LY/14/25/HH

Ubuntu Priory Farm Station Road Arundel BN18 9PH

Single storey extension.

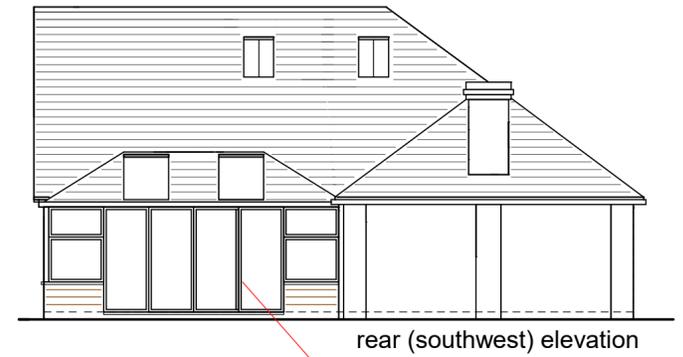
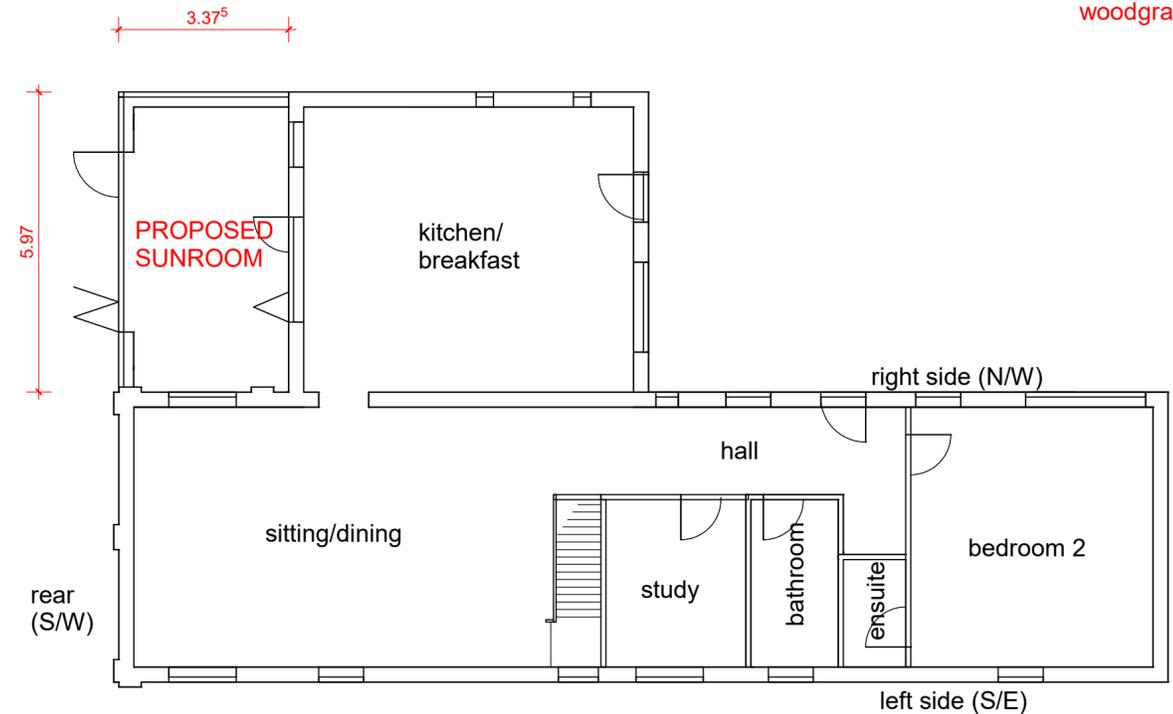
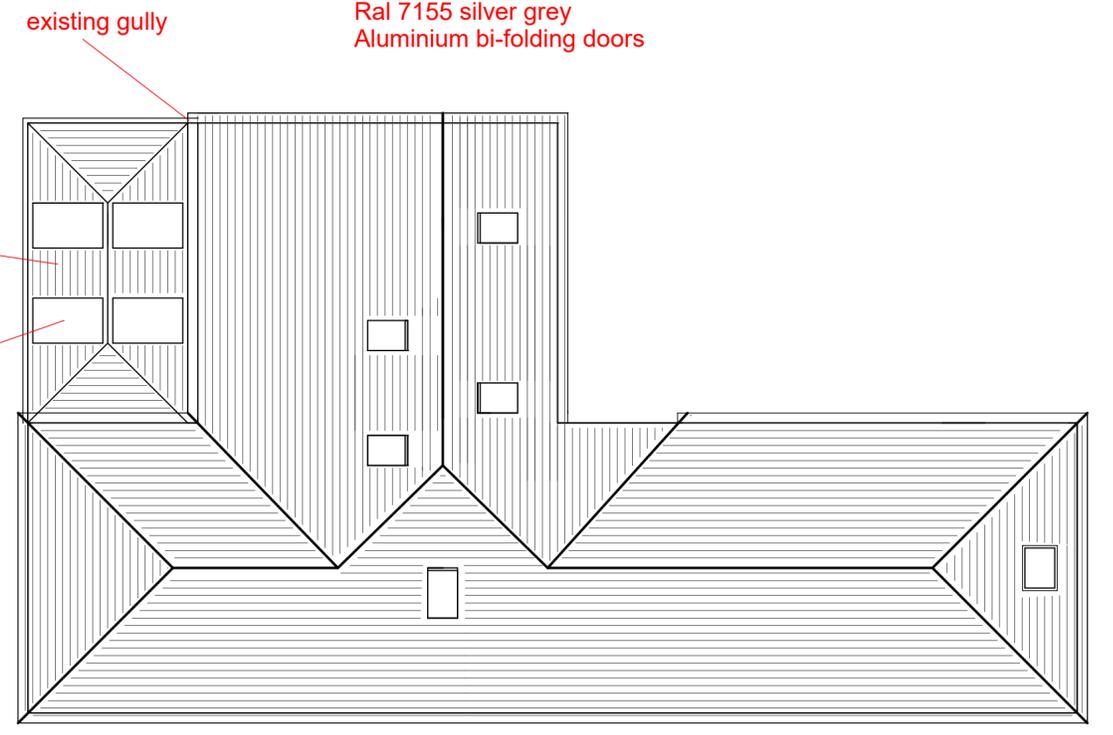
The proposal is for a modest single-storey extension which, in principle, appears acceptable in this location. Its siting and scale ensure that it remains subservient to the host building, and the intention to use a lightweight structure with generous glazing is appropriate in concept. However, the detailed design raises concerns. The proposed rooflights are disproportionately large, and the use of uPVC windows and doors is not supported. Standard modern rooflights are also unsuitable. Windows and doors should be timber, and any rooflights must be of a heritage type set flush with the roof slope to minimise visual impact.

Overall, while the principle of a modest single-storey extension is supported, the current detailing is problematic. The scheme should be revised to ensure the extension preserves the character of the building and achieves the least possible impact.
